From: Simon Davis
Sent: 24 July 2019 14:47
To: Rebecca Redford [REDACTED]
Subject: RE: Y/61/19/PL - Yapton Metal Company

Site Plan (Proposed) 1:200

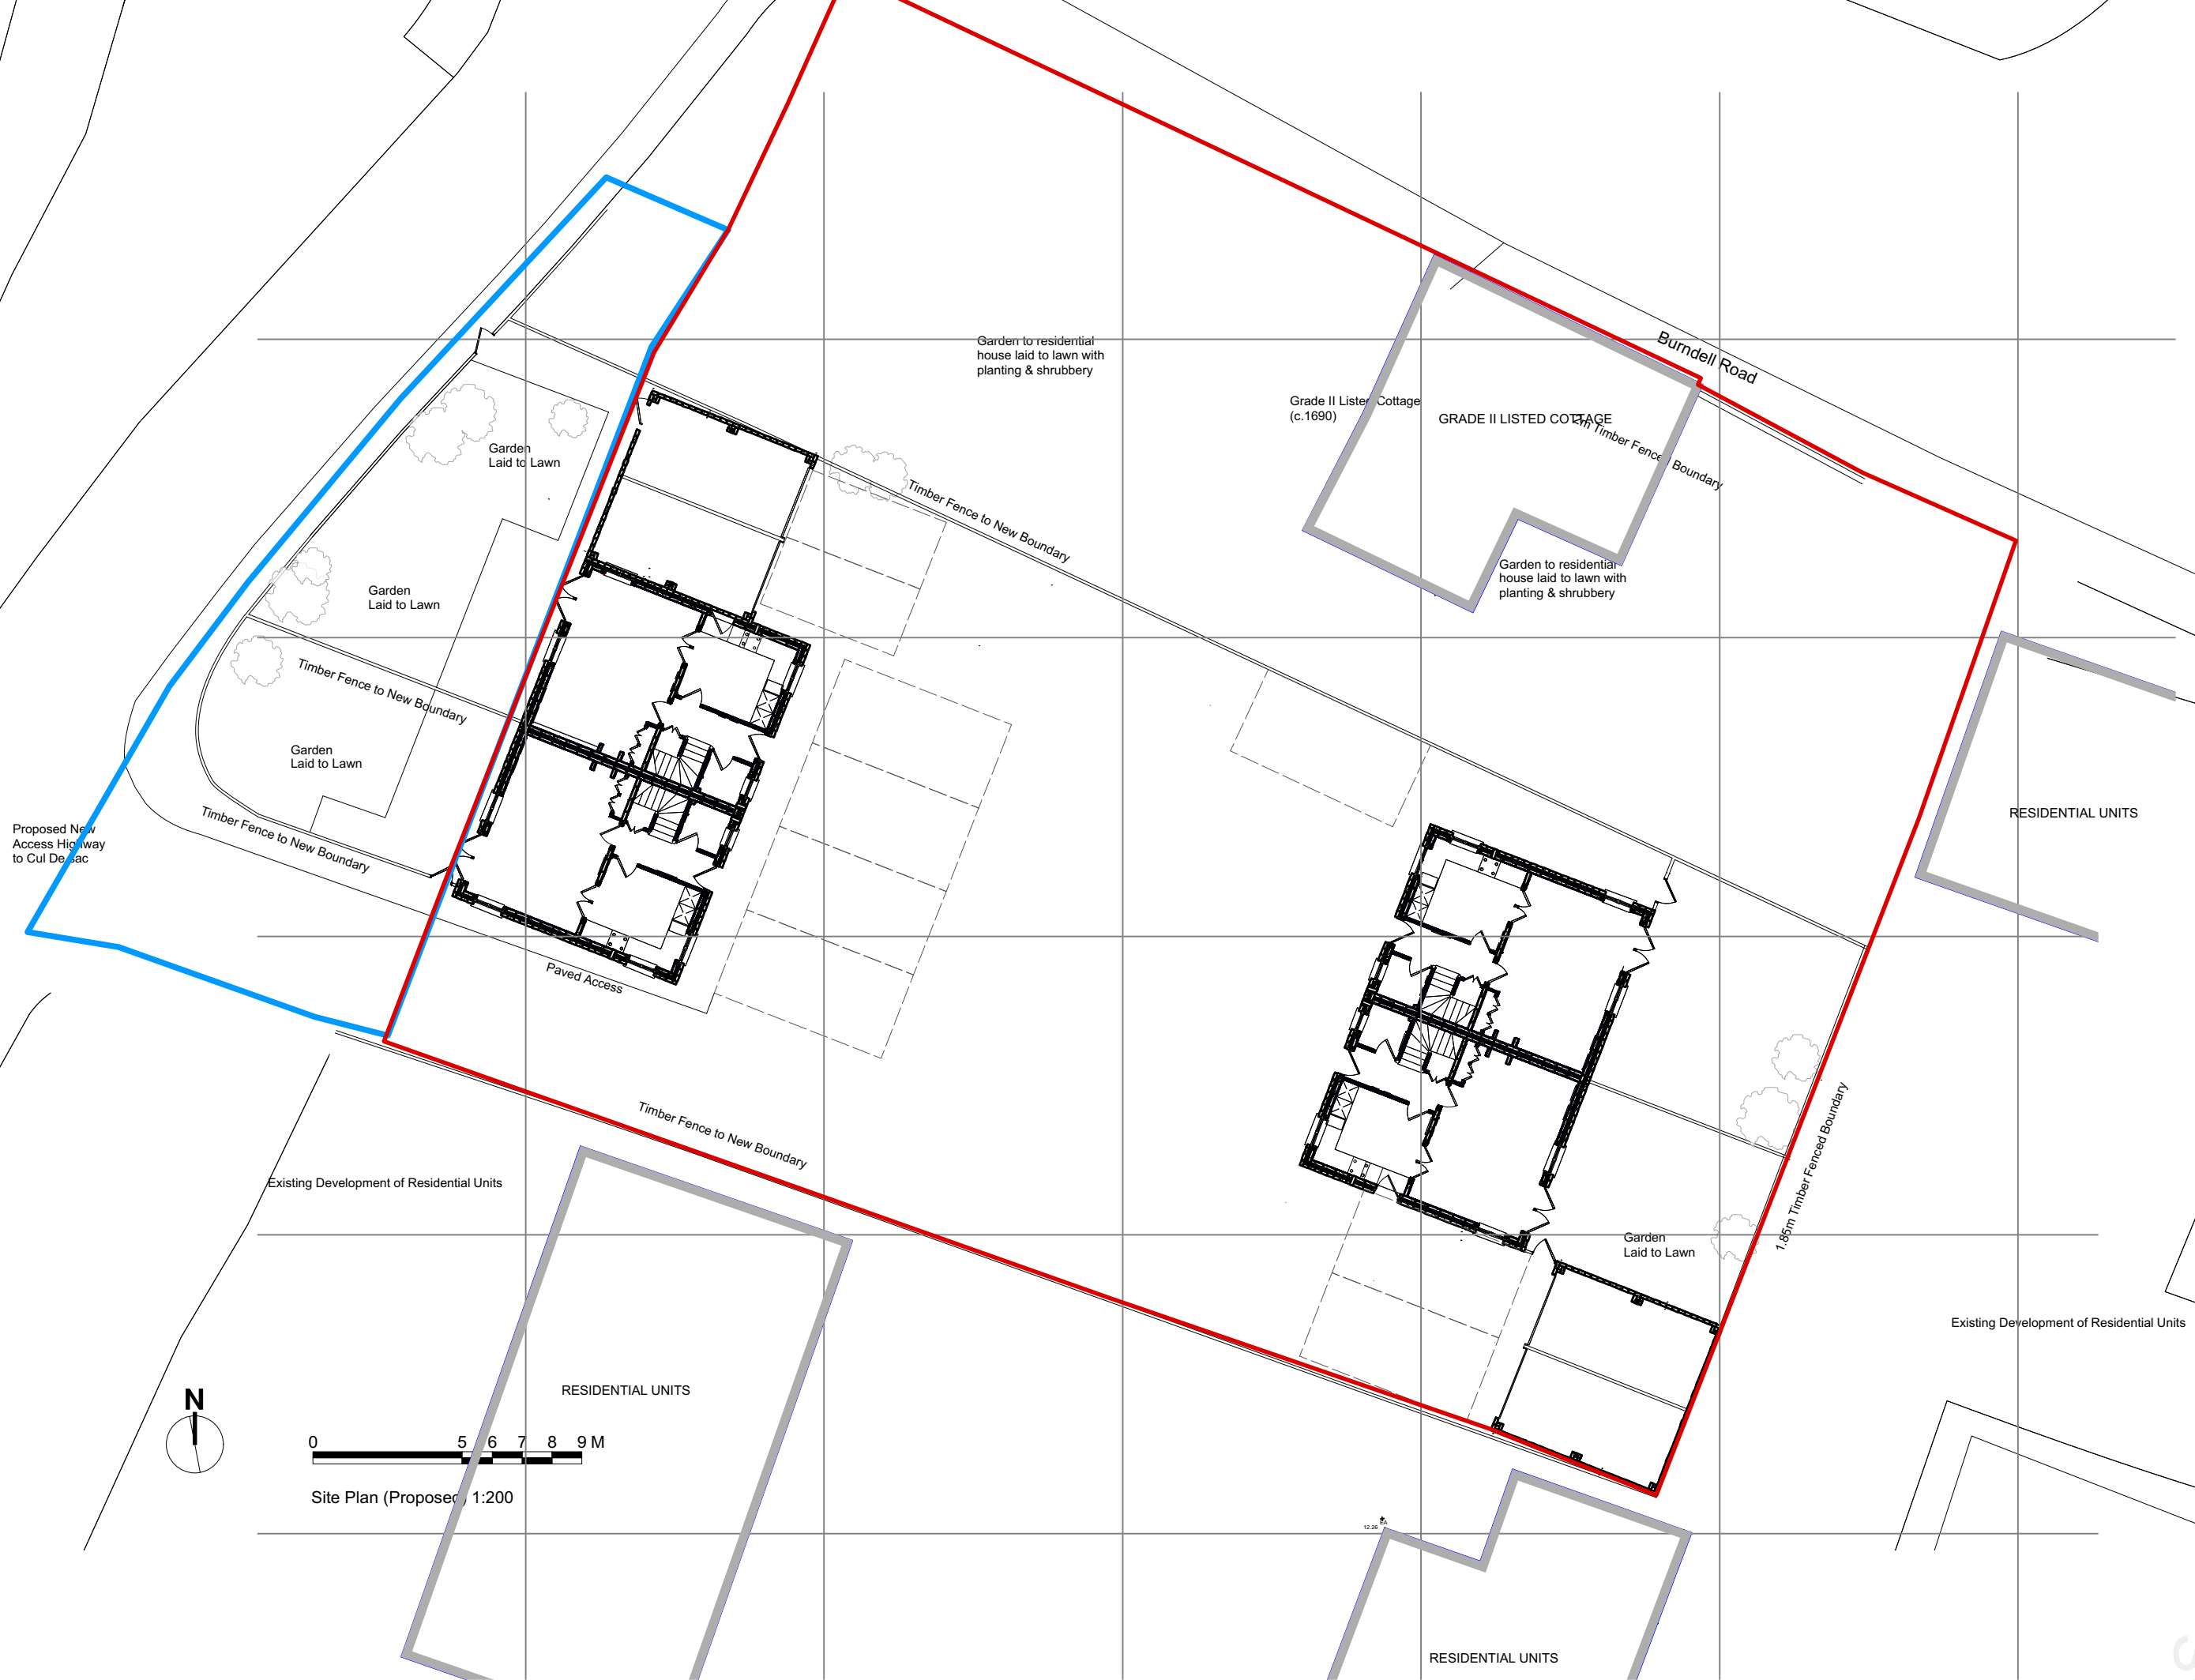
I have just been looking at the current DOC application. Two things; (1) can you advise when you are providing a further revised CMP in response to my email of 13/06/19 (as attached)? I note that the CMP received with Y/61/19/PL would also then need updating – or could it just be removed from Y/61/19/PL as it will be approved under the DOC so not point also having it as part of the planning application. (2) do the drainage drawings submitted with the DOC need to be changed due to the proposed flipping of the dwellings? I note that there is a blue drain line shown around the rear of the buildings and a red one shown to the front. Do these lines stay the same with the houses having flipped?
